ExQ1	Question to:	Question:	Nottinghamshire County Council Comments
Q1.0.1	All IPs	<p>Policy – National</p> <p>Do you consider NPSNN 2024 to be Important and Relevant to the Secretary of State's decision? If yes, how much weight should the decision-maker attach to the Proposed Development's compliance with NPSNN 2024?</p>	<p>NCC accepts that the 2015 NPS has effect for any application for development consent accepted for examination prior to 24 May 2024. However, NCC consider that the terms of the NPSNN 2024 is of importance and is of relevant material consideration for the proposed development. The county has considered relevant matters in relation to the NPSNN 2024 within its Local Impact Report [REP1-038].</p>
Q6.1.3	NCC	<p>Article 3 – Disapplication of legislative provisions</p> <p>Article 3(4) seeks the disapplication of the Nottinghamshire County Council Permit Scheme Order 2020. Is the County Council in agreement and if not please explain and justify your response, including why the usual notice provisions of the New Roads and Street Works Act 1991 would not be sufficient.</p>	<p>From the Nottinghamshire County Council Permit Scheme Order 2020</p> <p>All Works Promoters must

Figure 10.1 Material Assets and Waste Management First Study Area

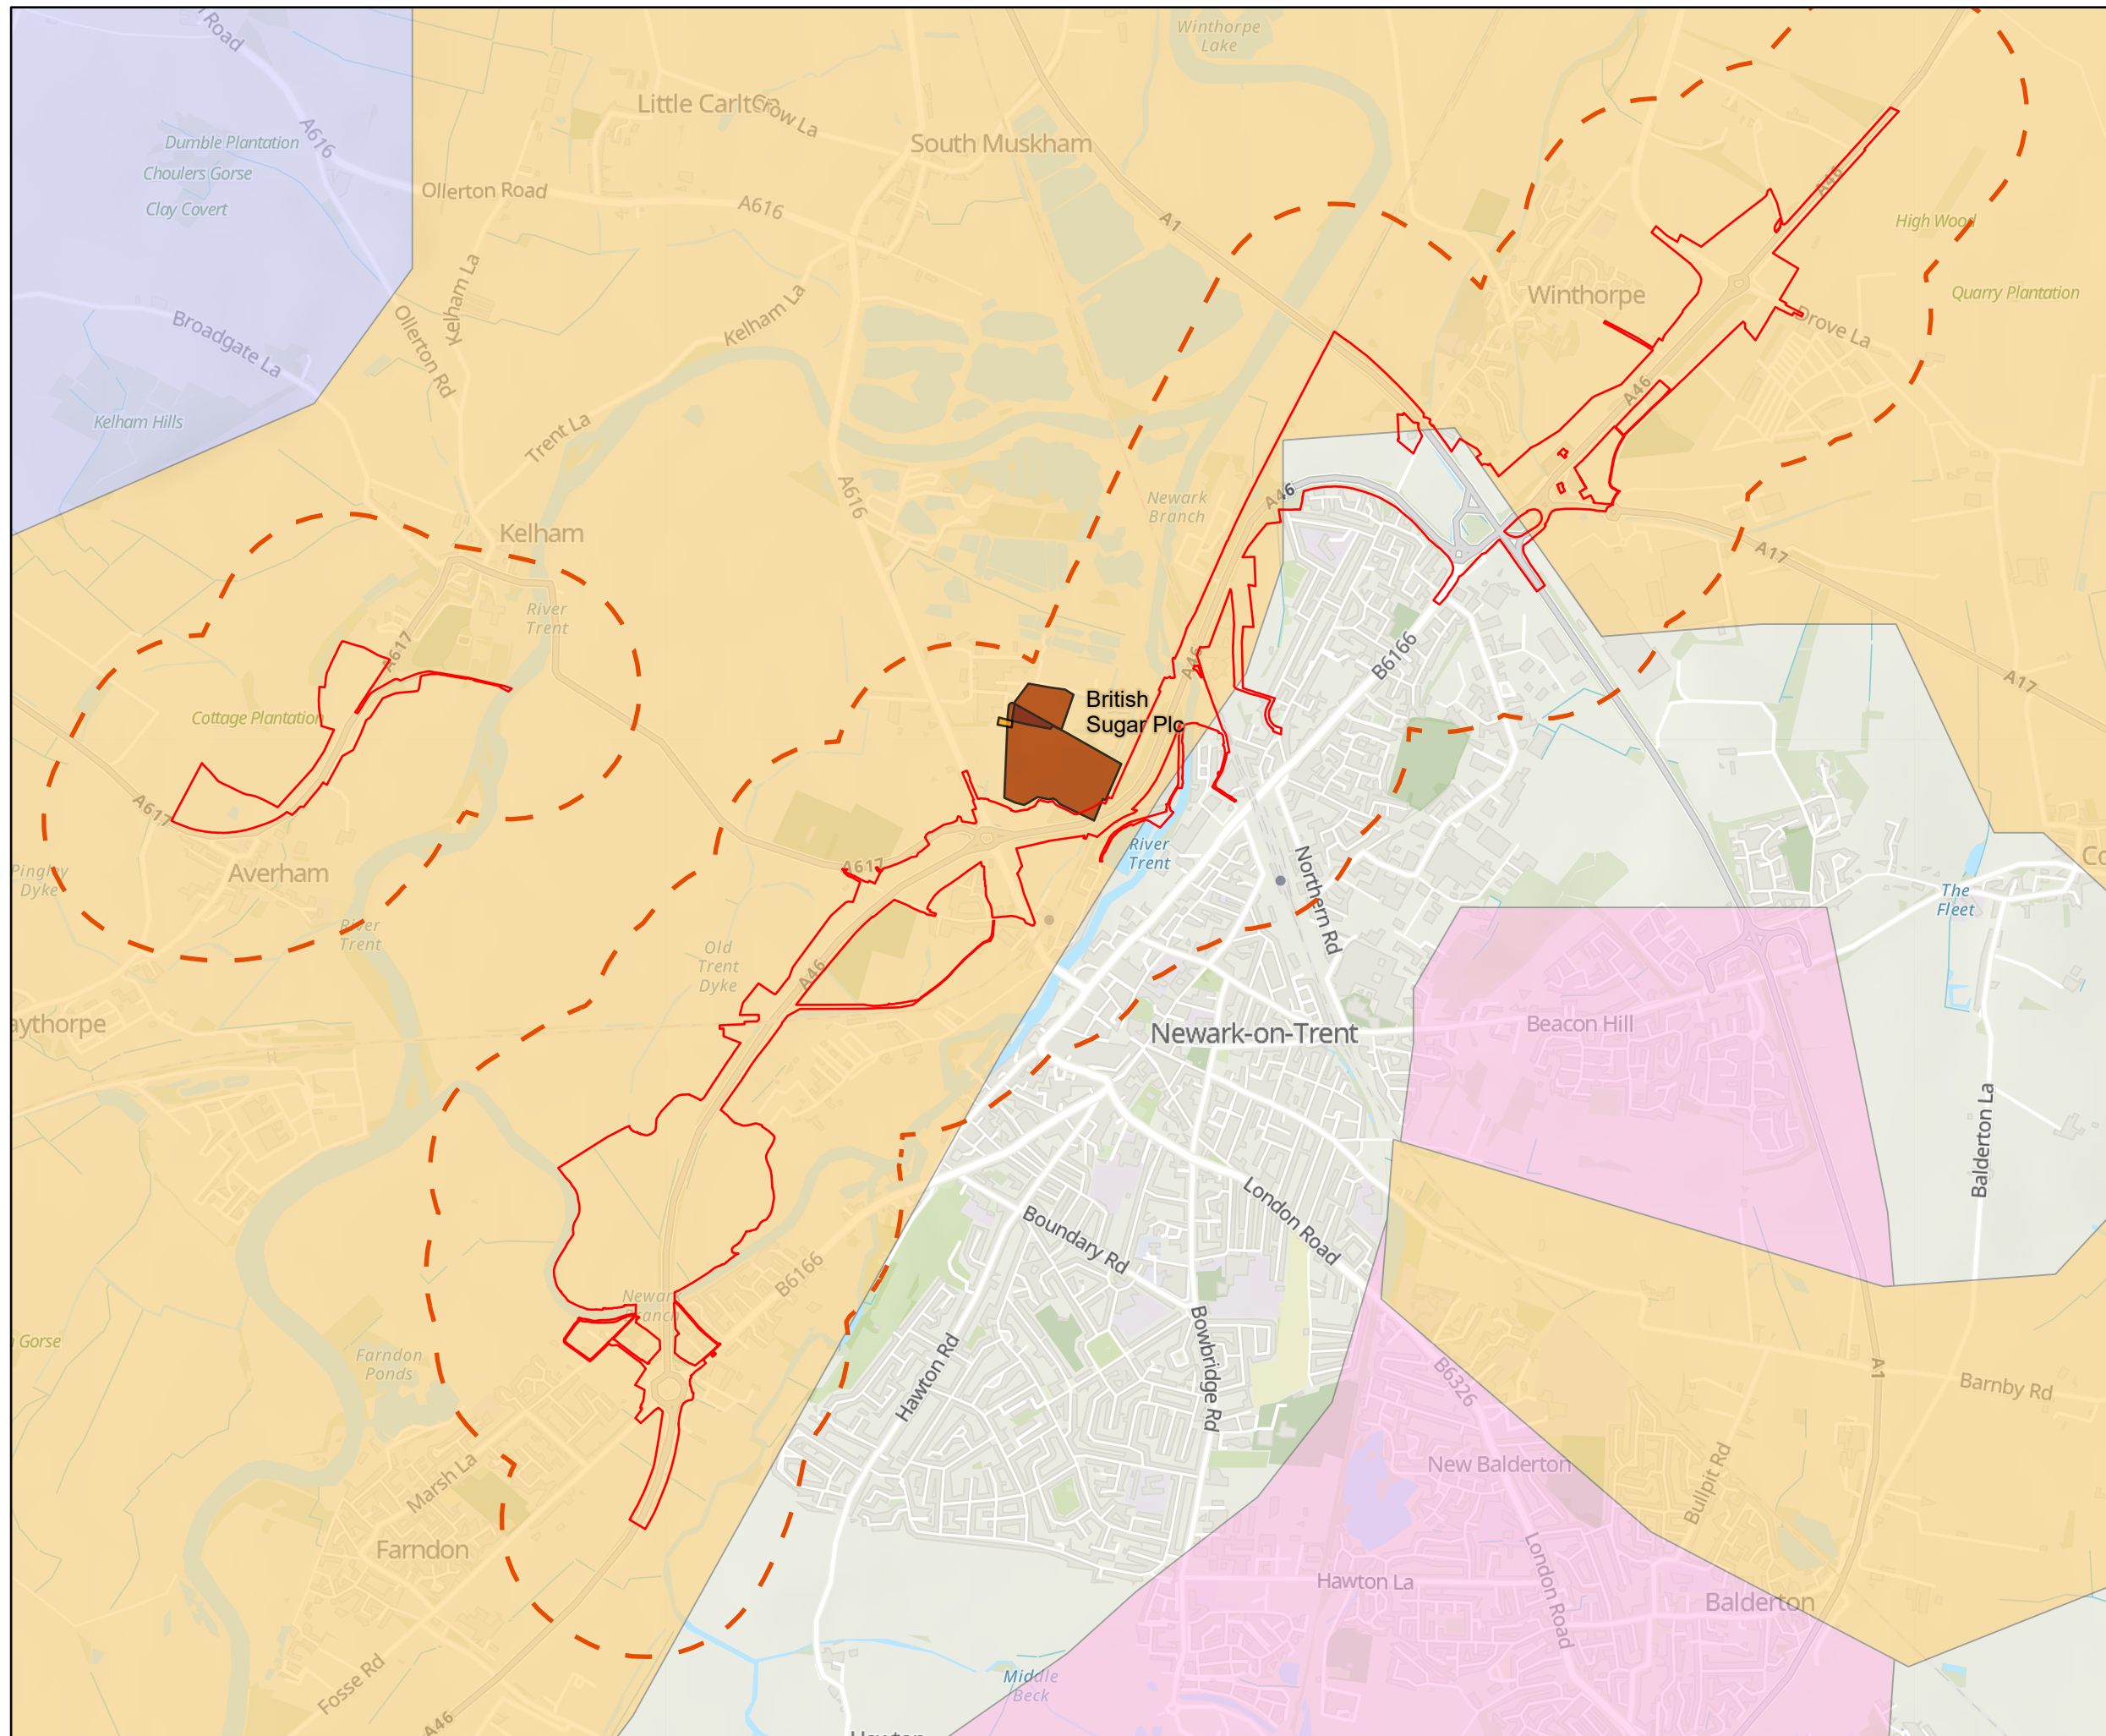
Q11.0.4	NCC	<p>Policy – Local</p> <p>a) Please provide a clear extract from the Nottinghamshire Minerals Local Plan (adopted March 2021) showing the area within which the Proposed Development would be located.</p> <p>b) Subject Area Plan C on page 160 of the Nottinghamshire Minerals Local Plan shows an area covered by yellow cross-hatching in a south-west to north-east direction. However, yellow cross-hatching in a south- west to north-east direction does not appear on the key. Please clarify.</p>	<p>a) Please find an extract of the Nottinghamshire Minerals Local Plan showing the proposed development area in Appendix A page 17.</p> <p>b) Unfortunately there is an error within the key for the mineral safeguarding and consultation area for sand and gravel, which should reflect the yellow cross-hatching in a south-west to north-east direction seen within Plan C. The County Council can confirm the yellow cross- hatching in Plan C is the mineral safeguarding and consultation area for sand and gravel.</p>
